September 24, 2018

**RE: Northbay at Lake Woodmoor, Final Plat SF-16-021 – 2<sup>nd</sup> Review Response**

This letter responds to your December 28, 2017 review letter relating to the above referenced project. Responses to review comments are shown in **red** below.

North Bay at Lake Woodmoor
Shoreditch Heights -- Plan and Profile
El Paso County, Colorado

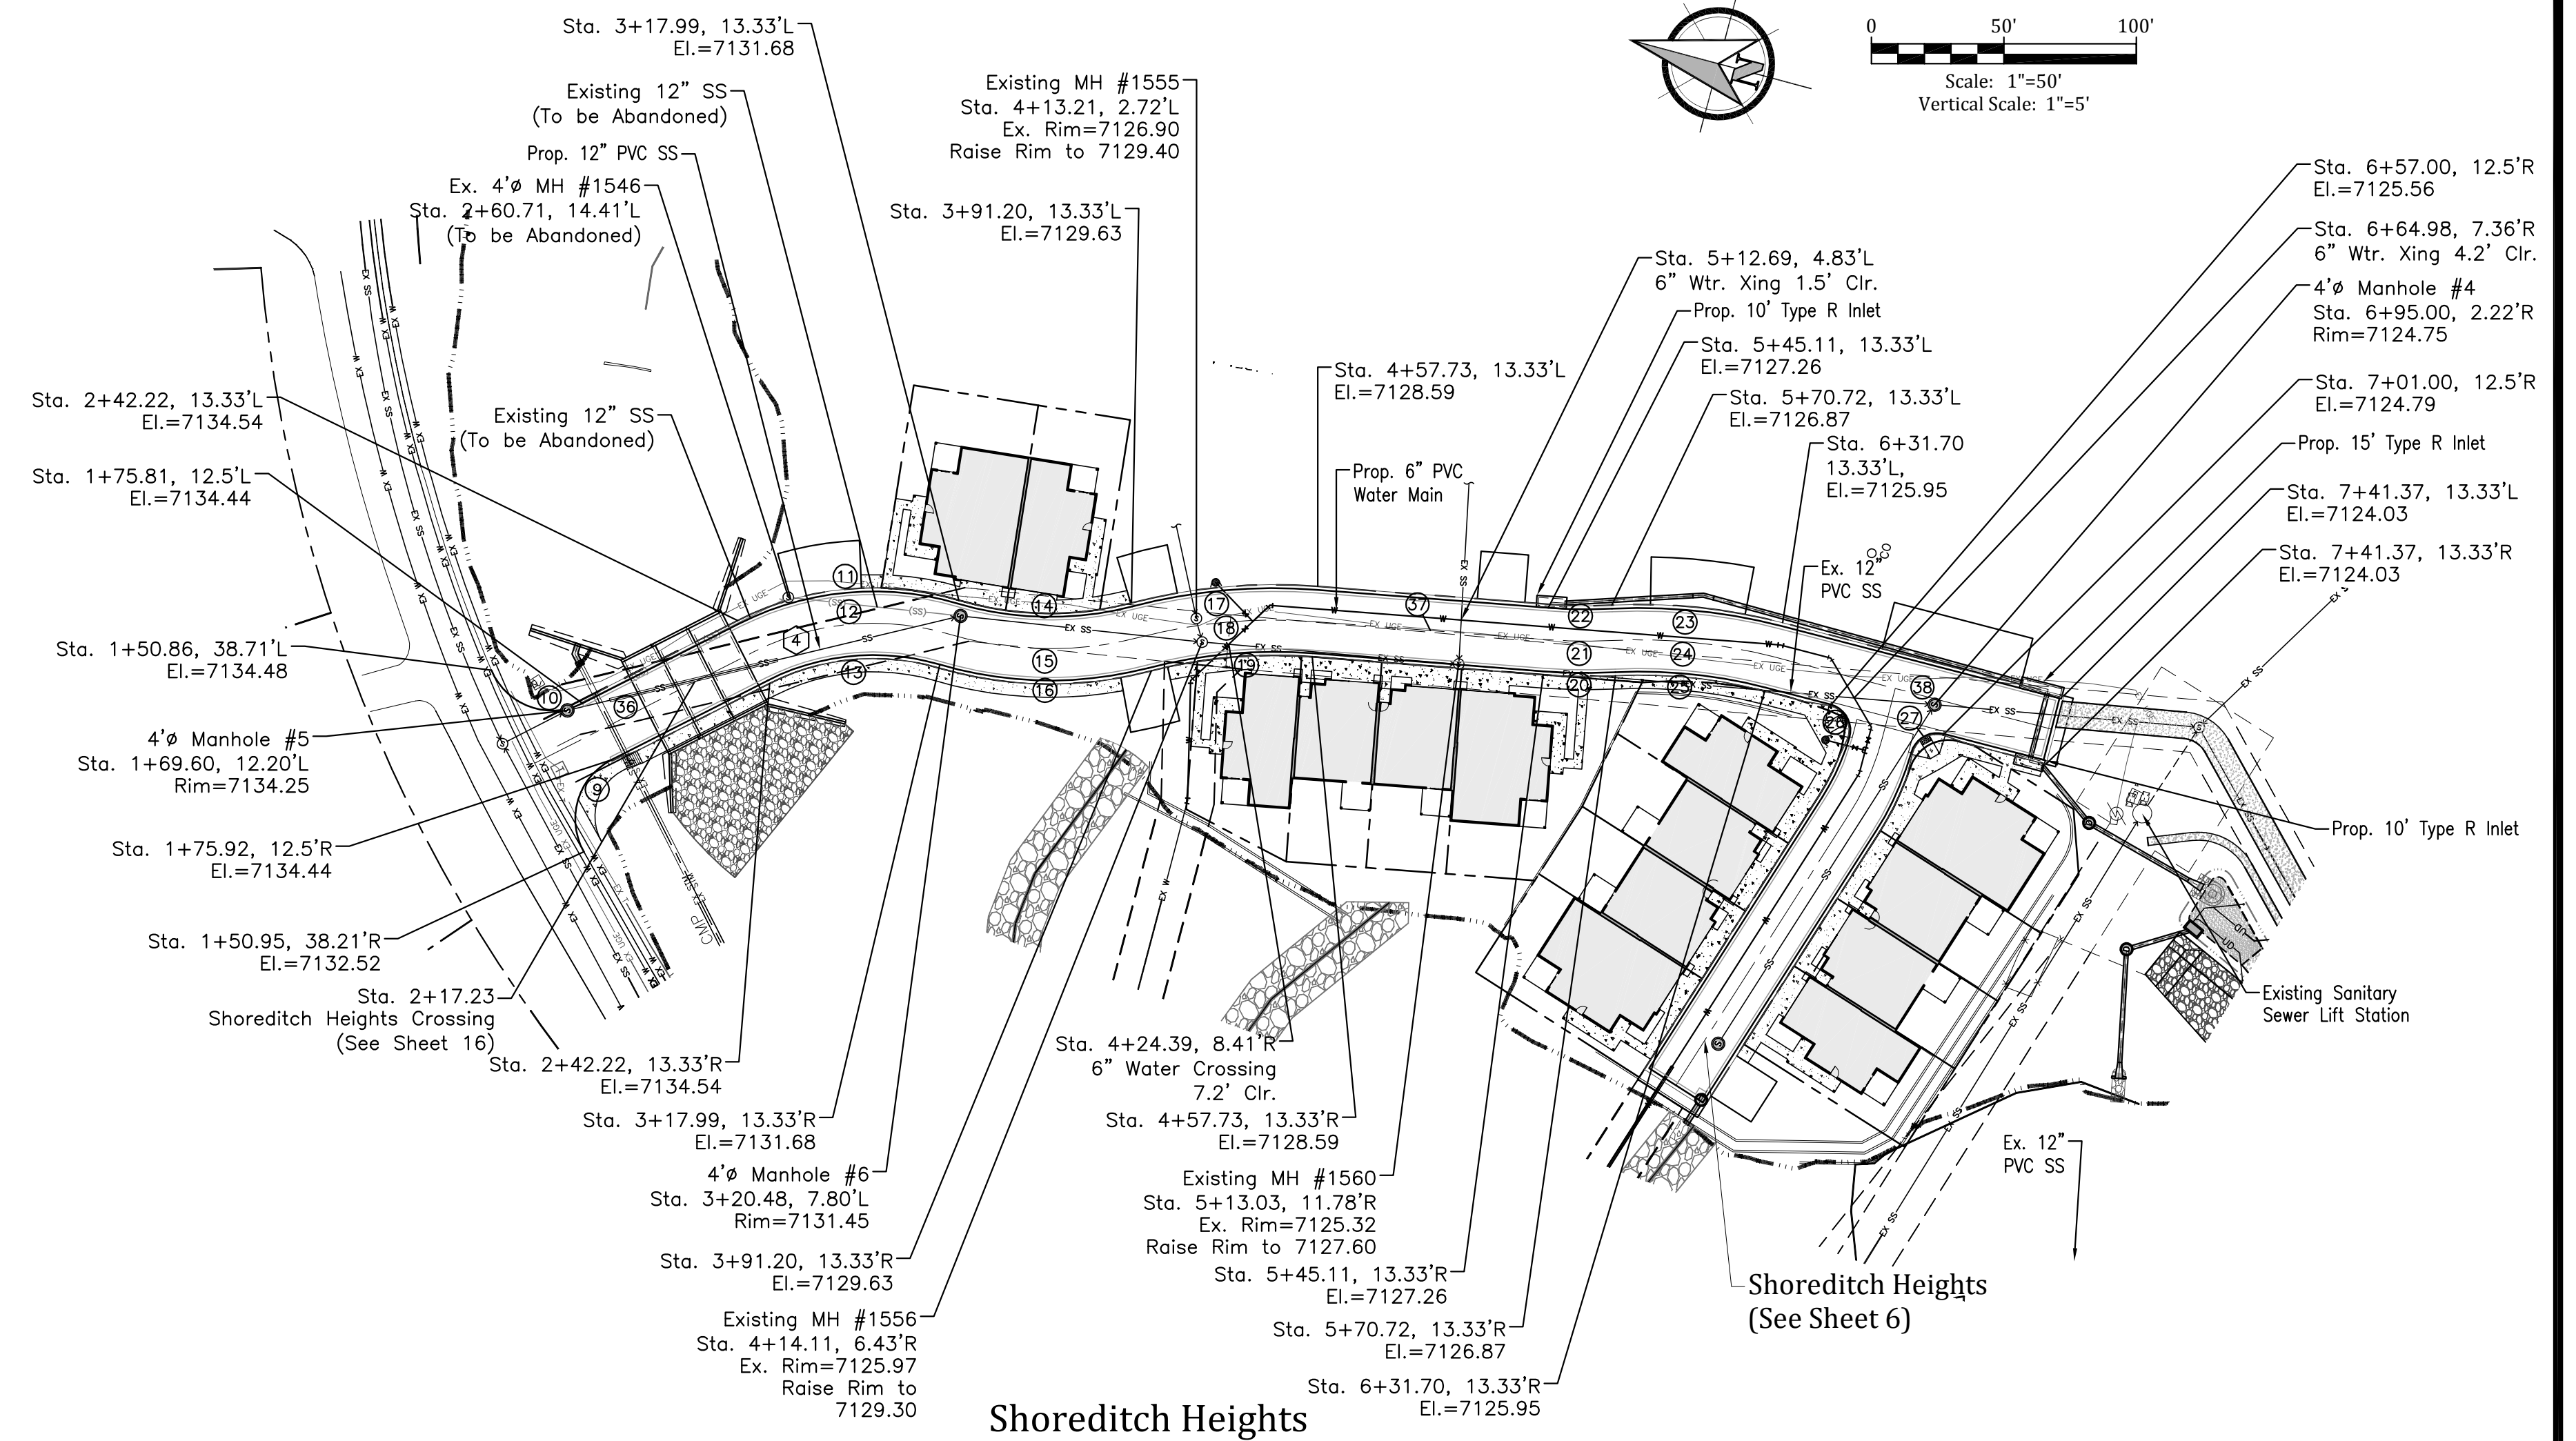
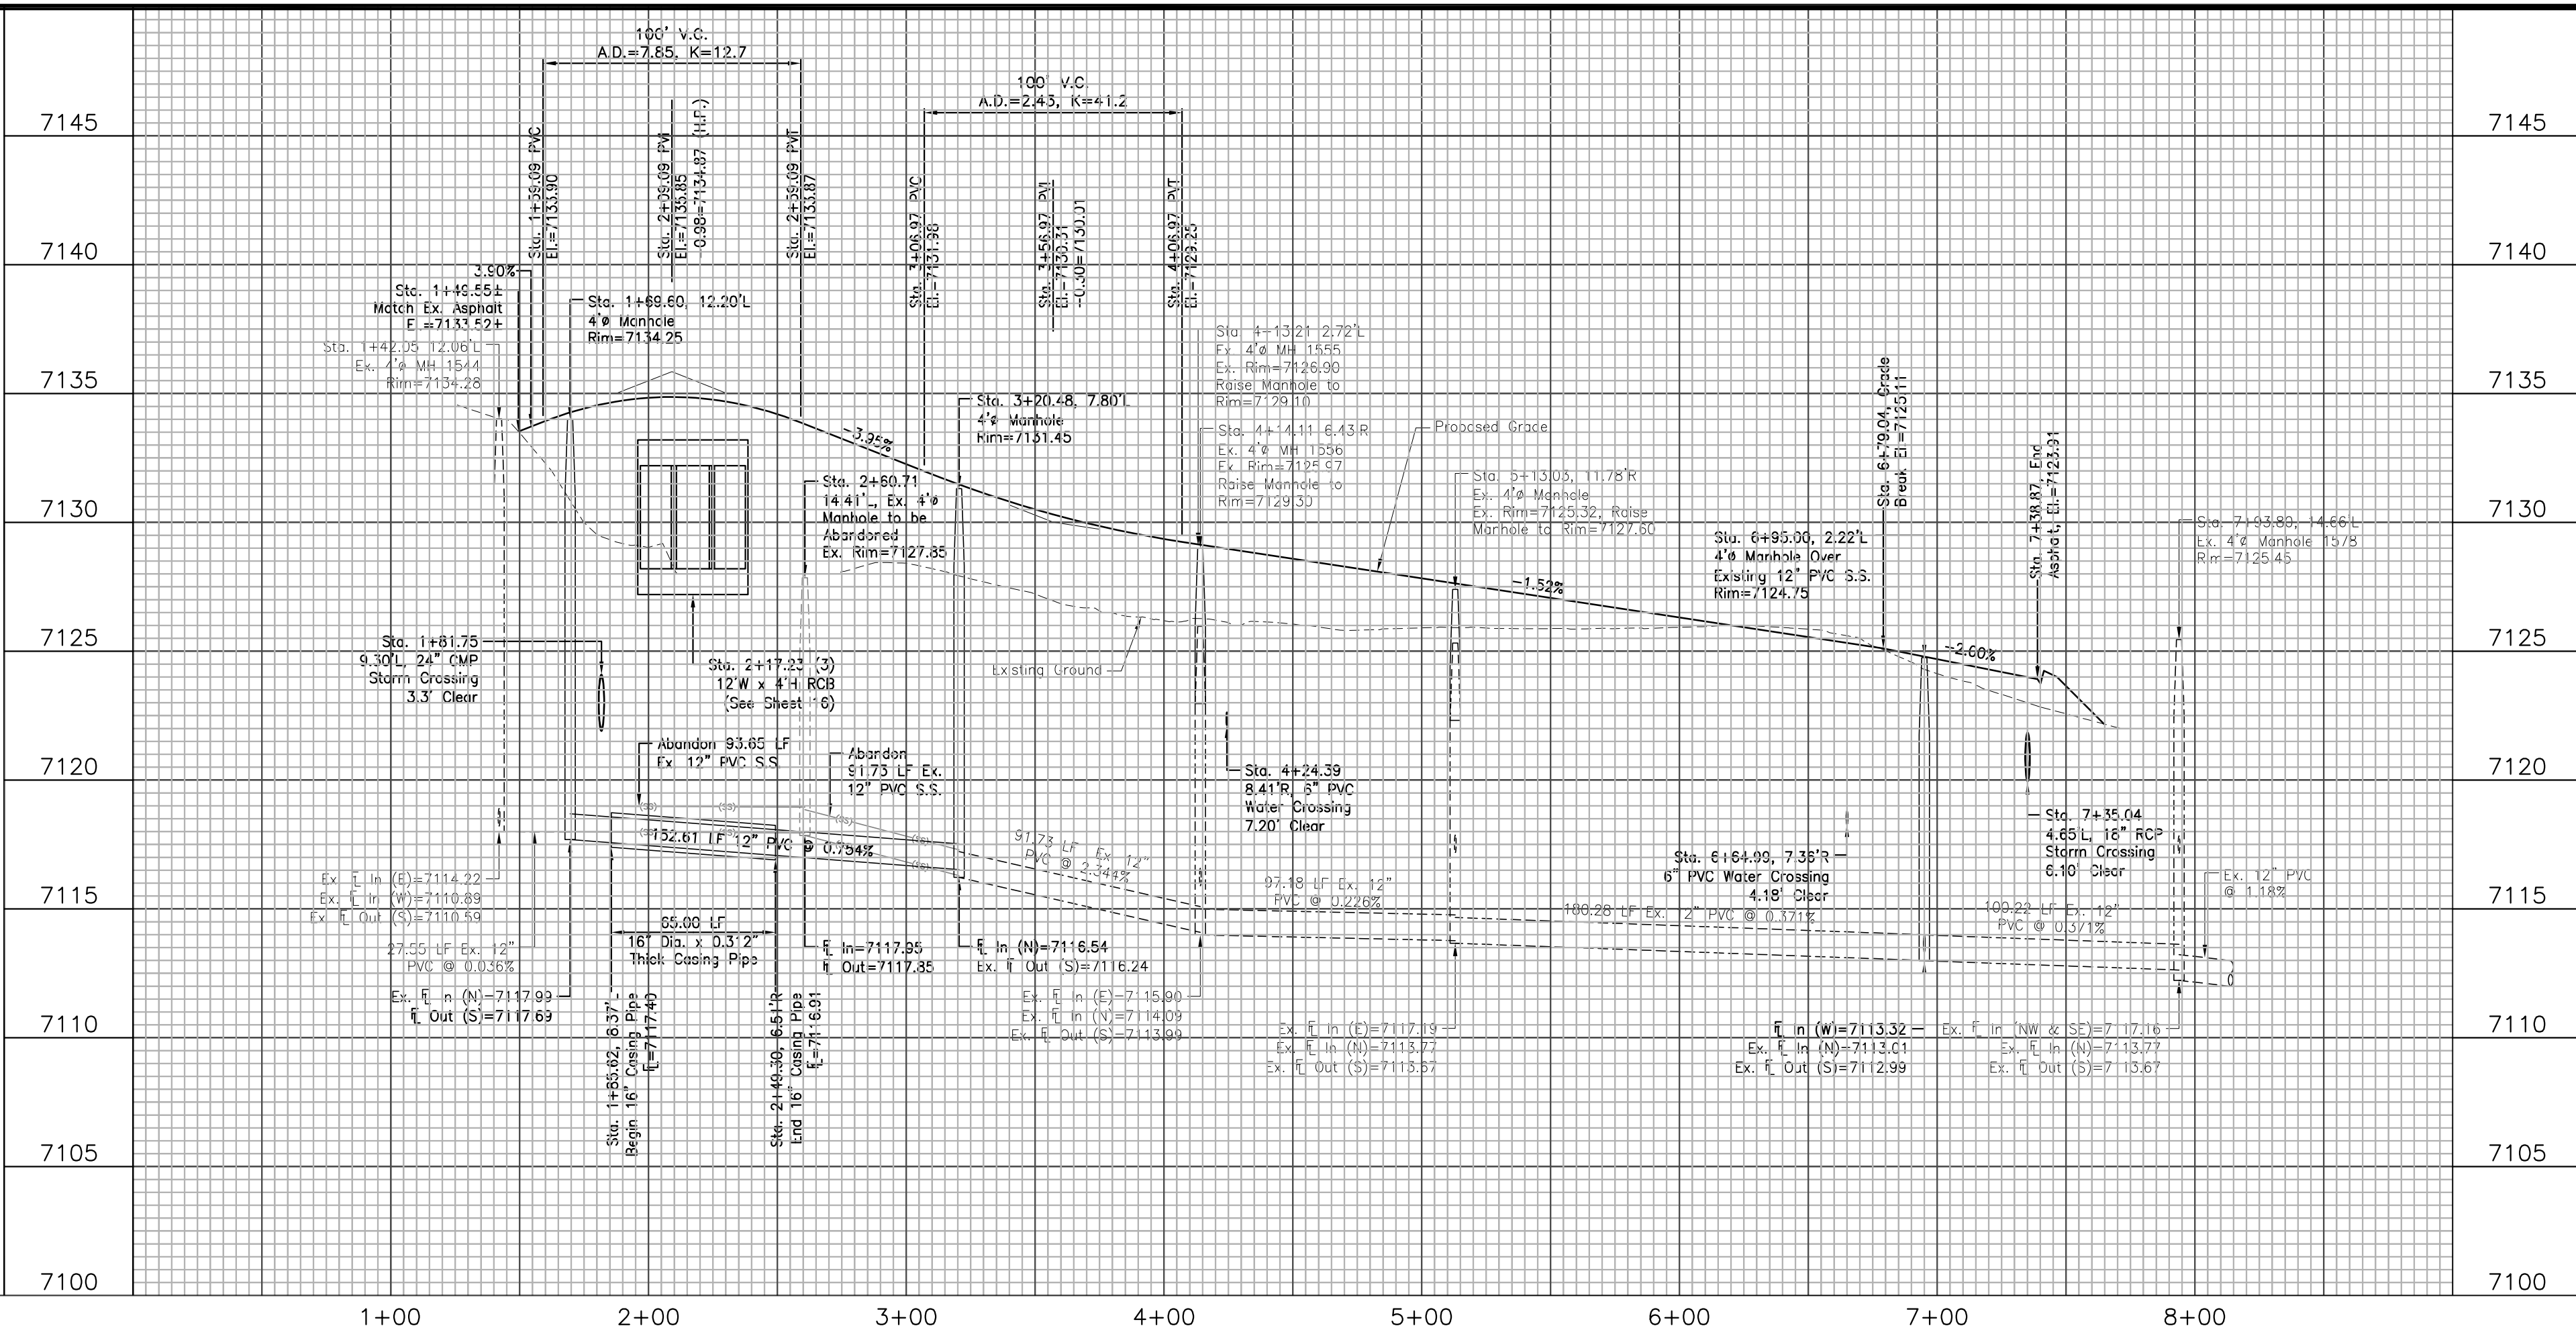
1. Resolved.
2. Unless modifications to the road way design standards are approved with the PUD Development Plan application (PUDSP-16-004), roadway design must be revised to meet the EPC ECM roadway design standards. The following does not meet county criteria: permanent hammerhead turnaround (ECM Section 2.3.8), minimum centerline radius (ECM Table 2-7), roadway cross section (ECM Section 2.2.4.B), vertical curve (ECM Section 2.3.4). **The PUD resubmittal identified these as PUD Modifications. If the County Commissioners denies these modifications the proposed roadways must be revised to meet EPC ECM roadway design standards. Noted.**
3. Roadway P&P sheets (6 & 7)

- a. Provide the stationing labels along the centerline on the plan view. **Unresolved.**  
**Provided.**
  - b. Resolved.
  - c. Resolved.
  - d. Resolved.

- e. Include the A.D. and K value in the vertical curve label. **See comment number 2.**  
**Provided.**
  - f. Revise the pedestrian ramp layout at the hammerhead intersection per ECM detail SD\_2-41. **Unresolved, but no additional action required since this is a private road. However, the ramps should be oriented perpendicular to the road, facing the other ramp. See the 2010 ADA Standards for Accessible Design for guidelines regarding diagonal curb ramps.**

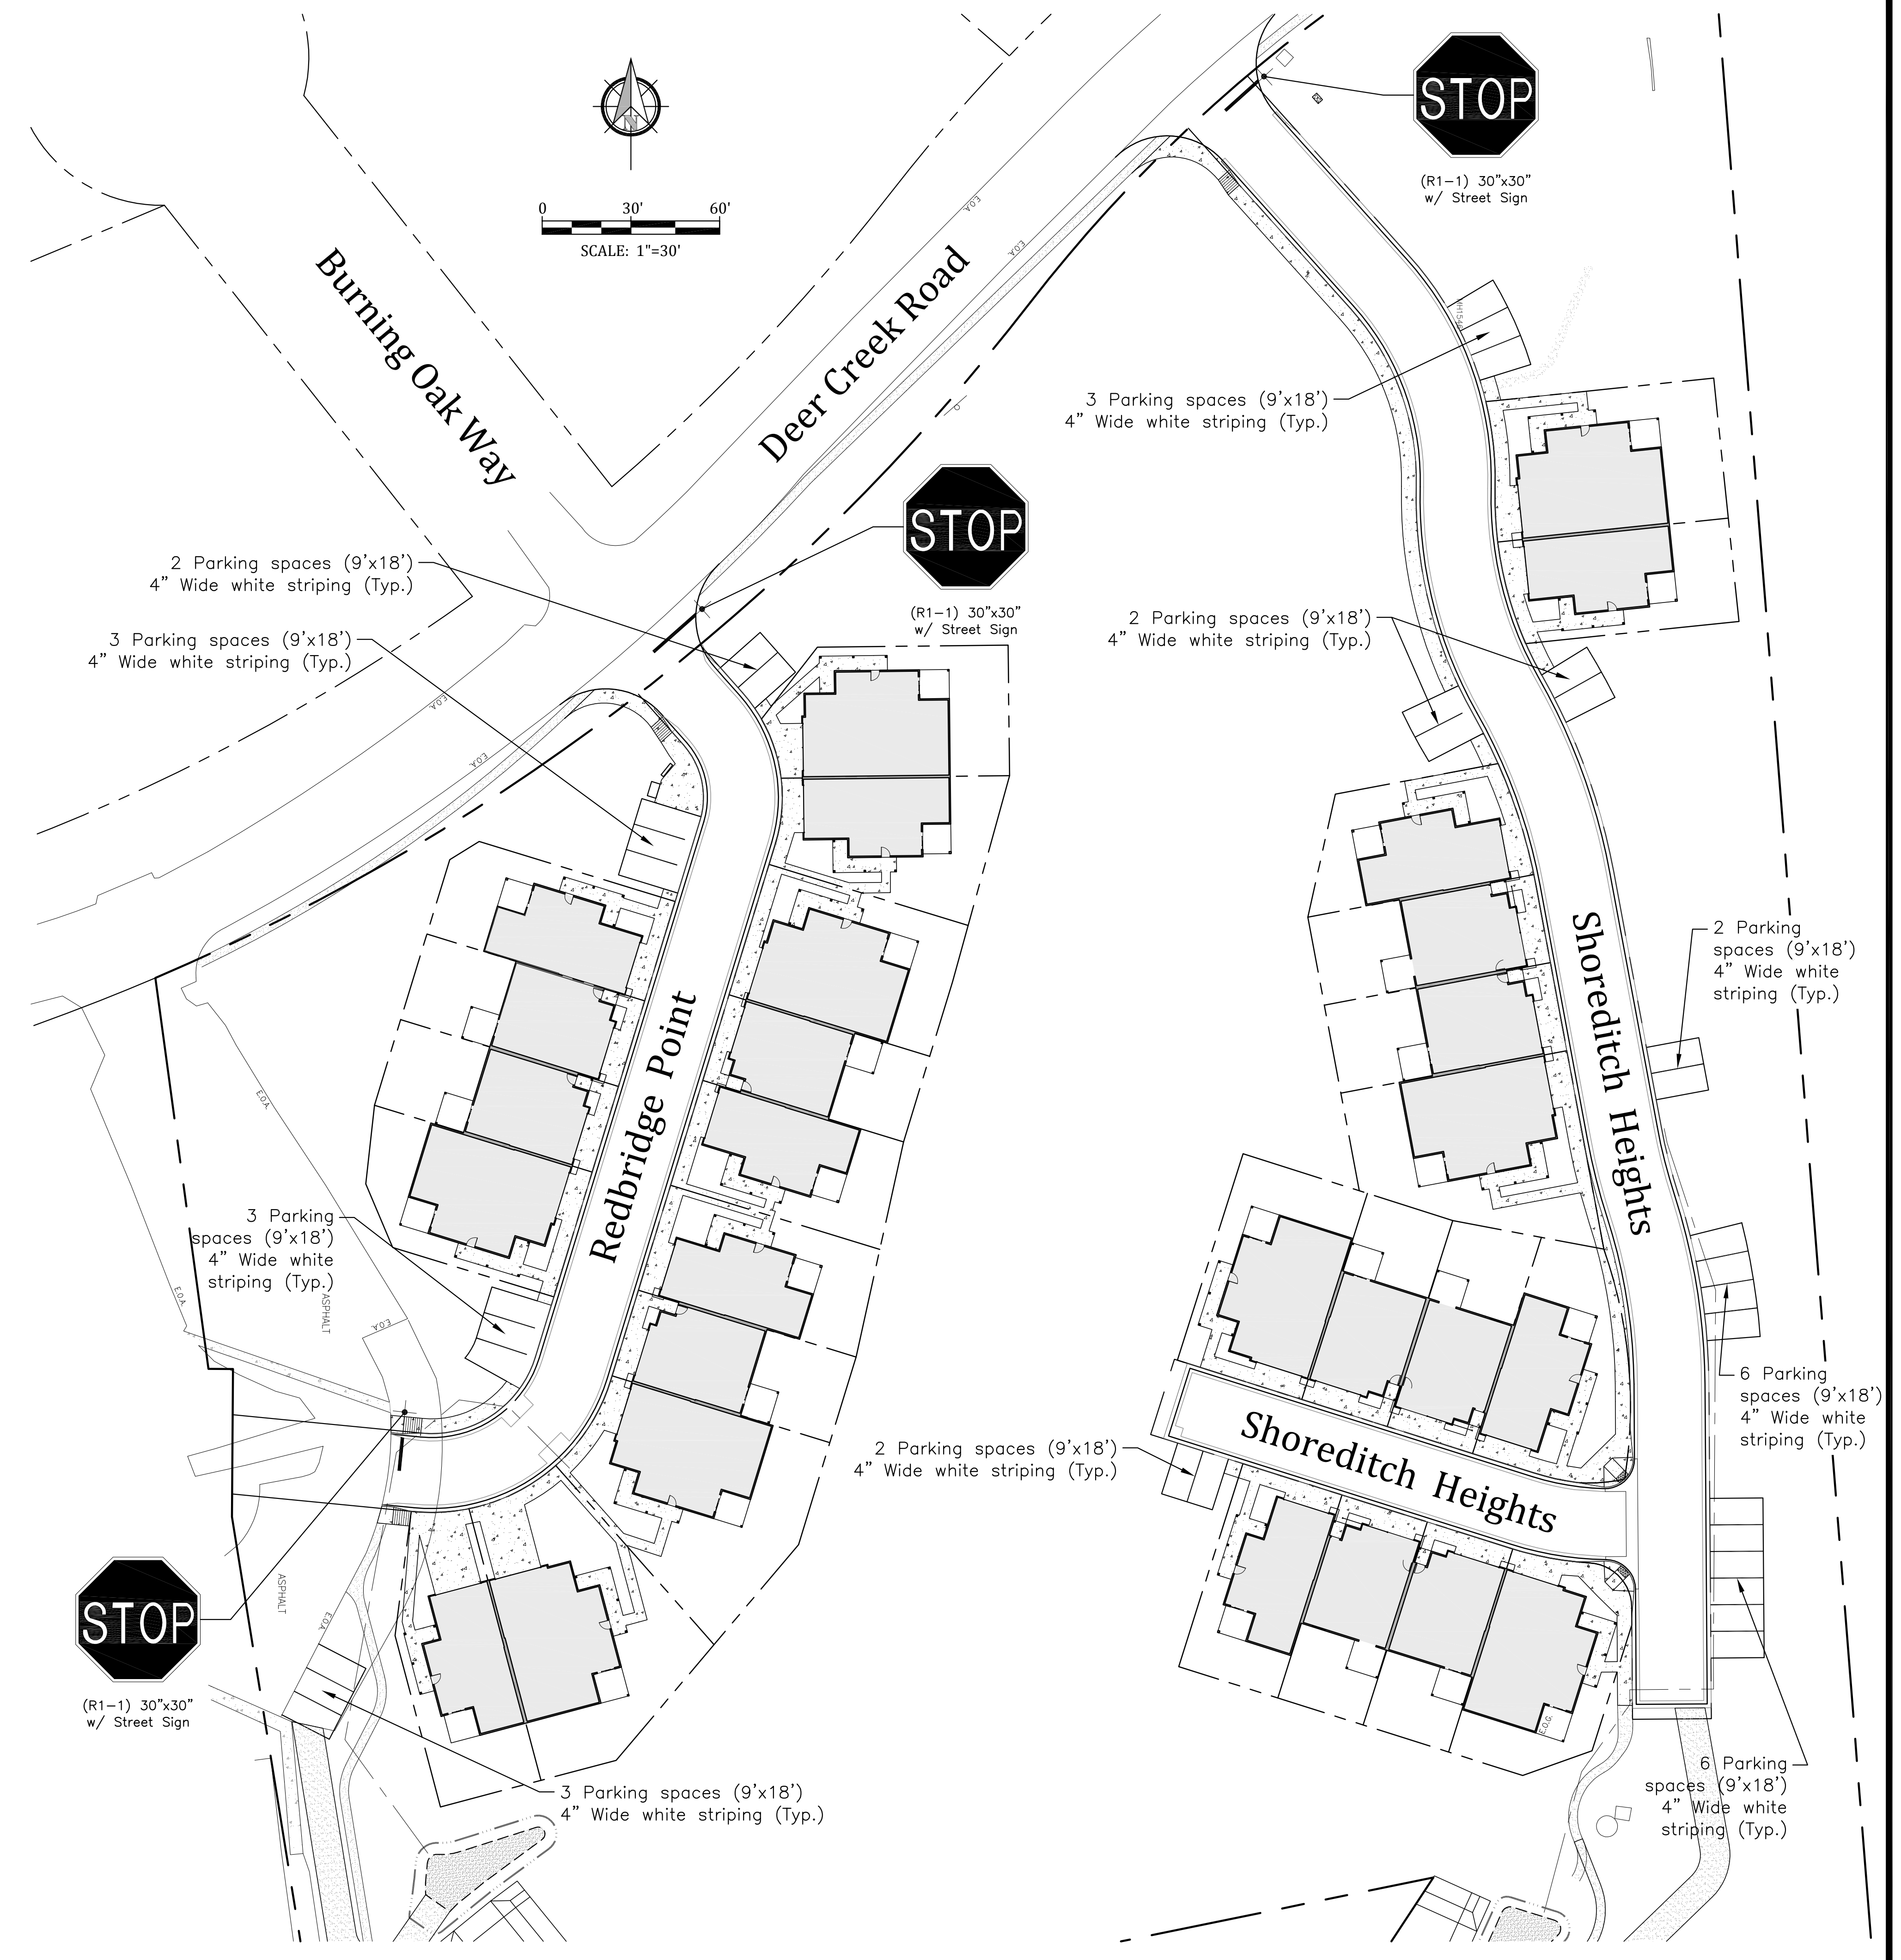
- 4. Provide a signage and striping plan and insert the attached County standard signage and striping notes. Also, is parking permitted on the street? **How do people know no on street parking is allowed since no sign is installed?** **The streets will be marked/painted as no parking fire lanes.**
